revised Permit # 2013-02563

City of Portland, Maine - Building or Use Permit
 389 Congress Street, 04101 Tel: (207) 874-8703, Fax: (207) 874-8716

Permit No: 10-1353	Date Applied For: 10/28/2010	CBL: 114A F003001
-----------------------	---------------------------------	----------------------

Proposed Use: Commercial - retail - install new signage Connected w/ permit#100547 (253 sf) & 8 new awnings (three 2'6" x 12' & five 2'6" x 8' 6') w/no signage	Proposed Project Description: install new signage Connected w/ permit#100547 (253 sf) & 8 new awnings (three 2'6" x 12' & five 2'6" x 8' 6') w/no signage
---	--

FOREST AVE ELEVATION

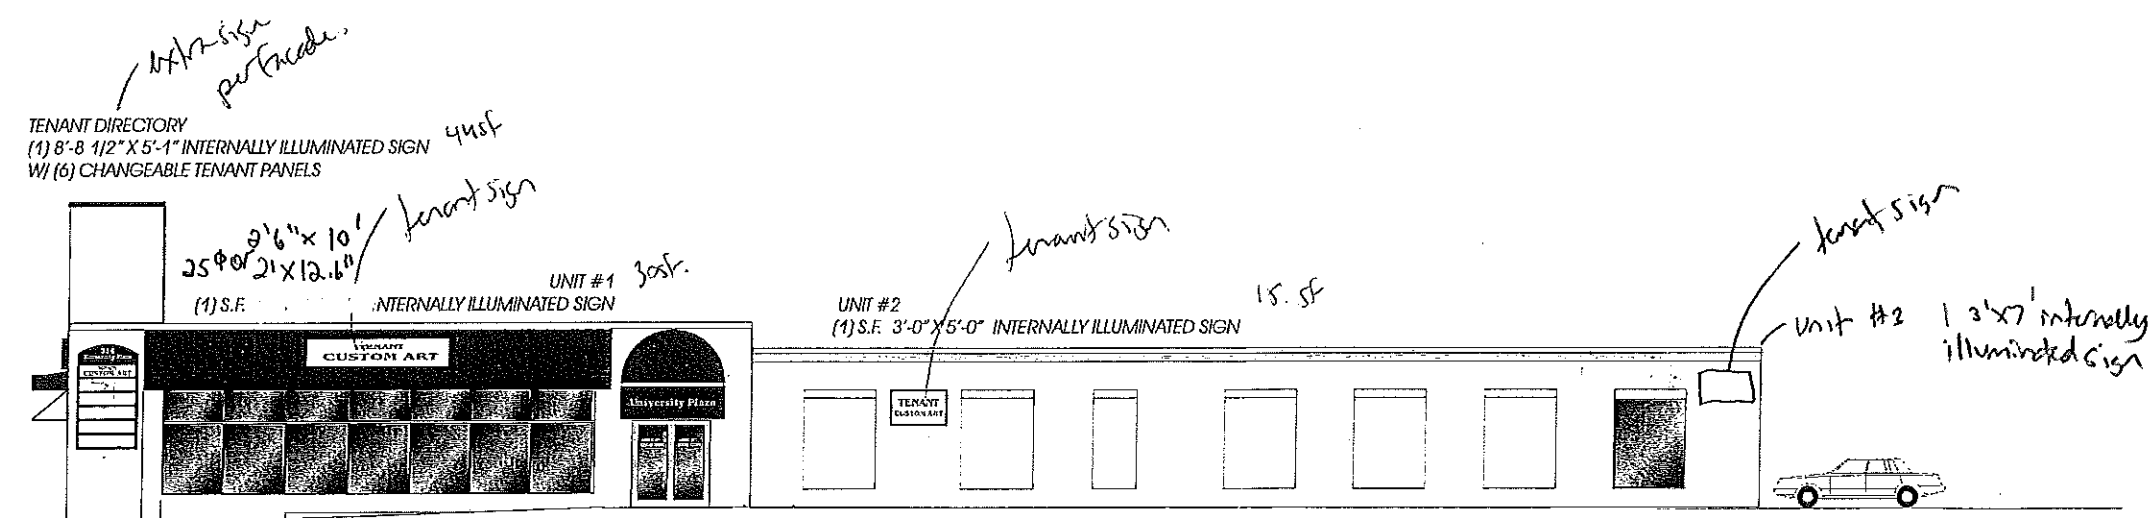
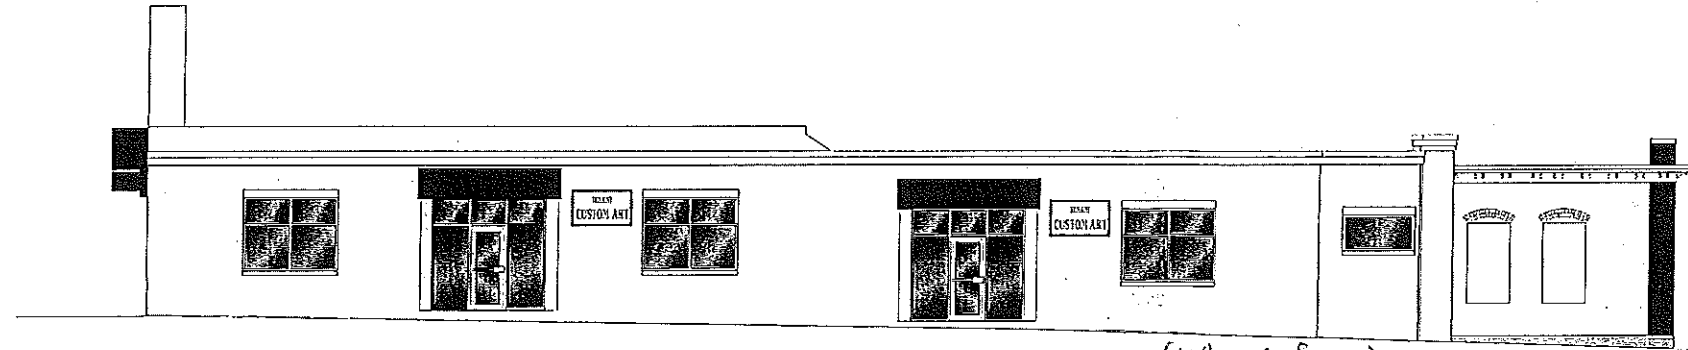
11/1/2010-amachado: Left vcm for Deanna Emery. Proposed signage exceeds what tis allowed. Can only have one directory sign and each panel must be max. of 1.5 sf. Can't have sign for both Tenant3 on Bedford St. Are awnings part of permit?

11/3/2010-amachado: Met with Bruce Bailey. Looking at the building sign options. Using Alternative 2 under Table 2.13 with a sign plan.

11/12/2010-amachado: Received revised application to add 8 awnings and change size of three proposed signs. Nedd confirmation of how many new awnings there are and the cost of the awnings to figure out difference in the fee. Bruce Bailey is out of office untl November 17, 2010 so left message with Deanna Emery.
